Planning Application Ref: R/14/18/T

Location: Land R/O 12 Bushby Avenue, Rustington

Description of works: Raise crown of 1No. Evergreen to 5.5m - 6m over carriageway

SKETCH 18.1 SITE PLAN - (EAP OF 12 BUSBY / WAVERLEY RD

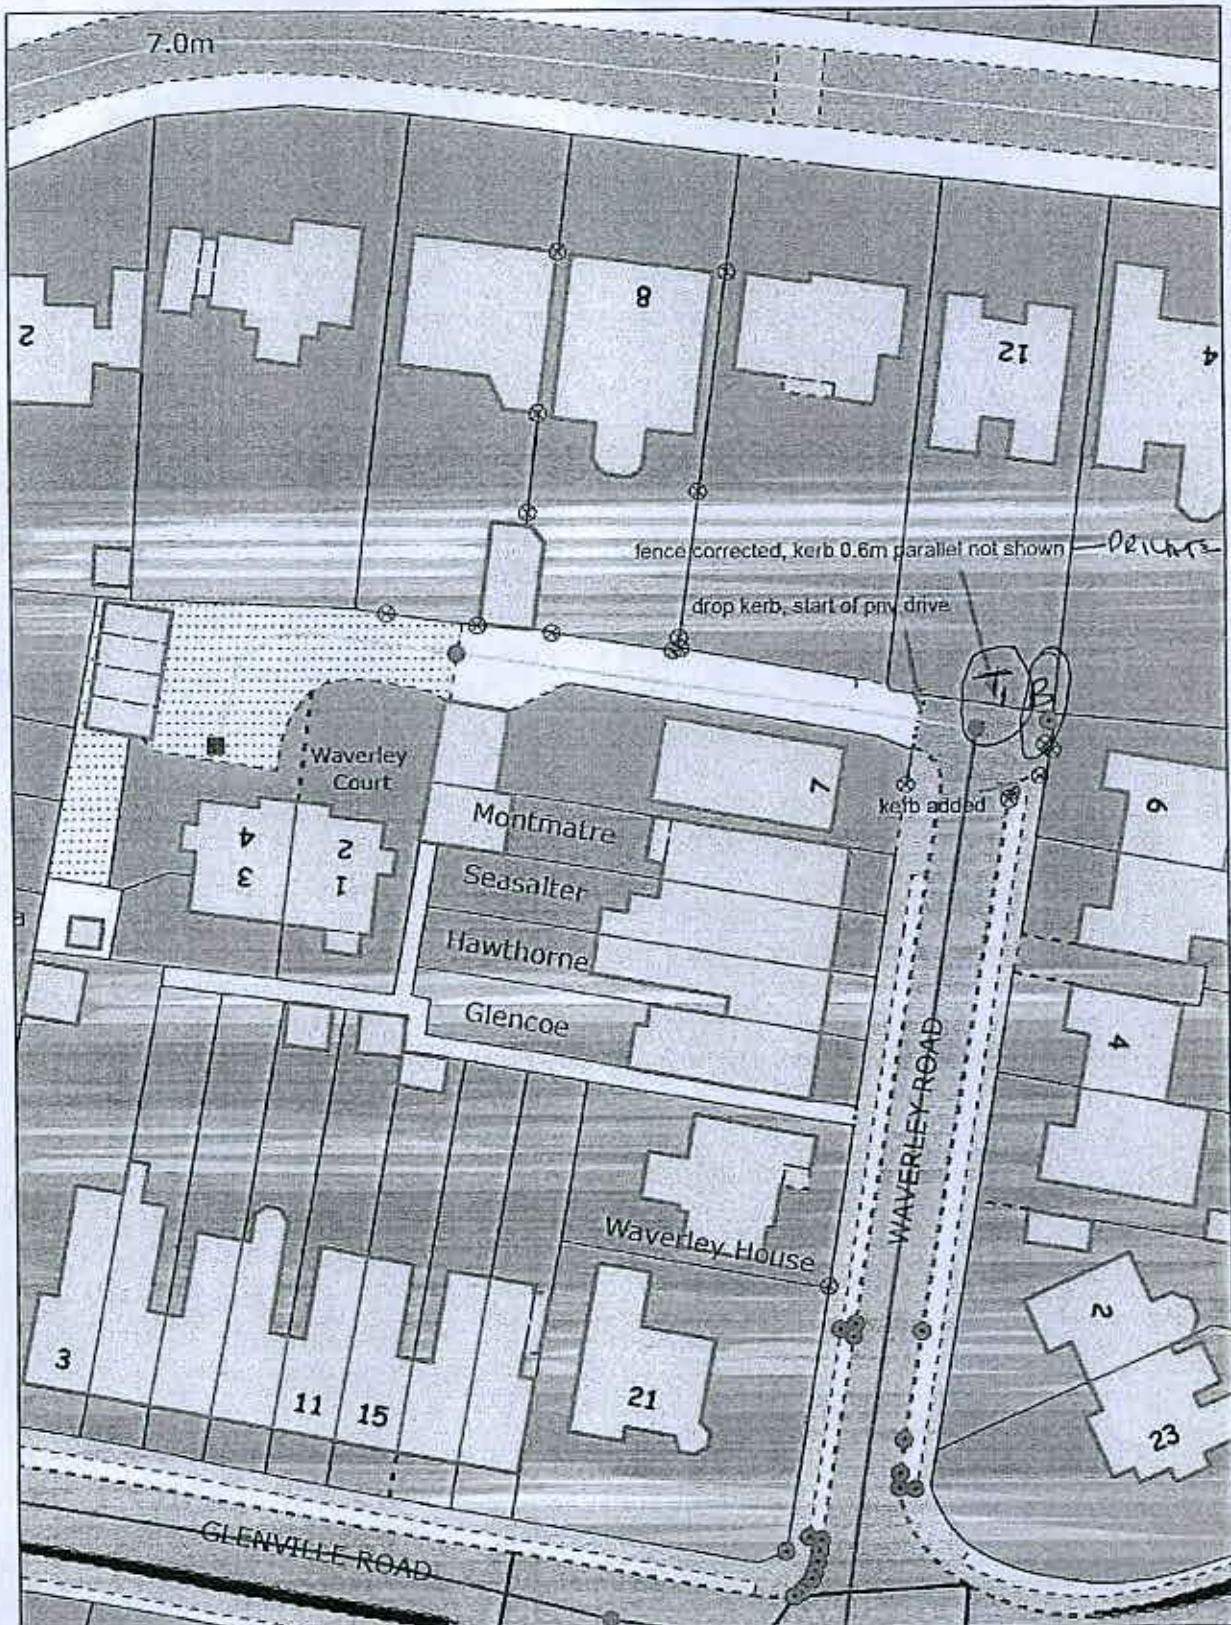
- This tree has prominence; providing a notable ornamental backdrop to persons/vehicles entering Waverley Road. From that aspect it has good form.
- My assessment of its condition was restricted to viewing from Waverley Road and partially restricted by a high boundary fence - so I cannot comprehensively determine its structural state. It has a minimum of three major stems arising from near ground level (<2m ht.).
- From a southern aspect it appears to be in a fine physiological state and generally structurally sound. It has an attractive crown profile typical of its type, although ivy has become established and may inhibit satisfactory future branch development.
- The adjacent small tree (described as bush (B1)) is bay laurel and not included in any Order, so no formal consent from the local planning authority is required before undertaking any work.

- The work proposed is justified as low growth is at a height that may interfere with the passage of high-sided vehicles.
- While erring on the excessive side, if this work is undertaken to a high standard and in strict accordance with the recommended conditions it will not incur a sustained loss of amenity value to the surrounding area.

- The removal of low branches to achieve 5m overhead clearance will be adequate to maintain safe passage for high-sided vehicles and is unlikely to need repeating in the short-term.

- The extent of overhead clearance achieved following branch reduction/removal must not exceed 5.5metres.
- Where whole branches are to be removed and final cuts made close to the trunk or branch union they are to be made as shown in Figure 2 of BS3998:2010
- Where branches are to be shortened back the final cuts are to be made at the correct angle shown in BS3998:2010 and adjacent to a live bud or lateral.
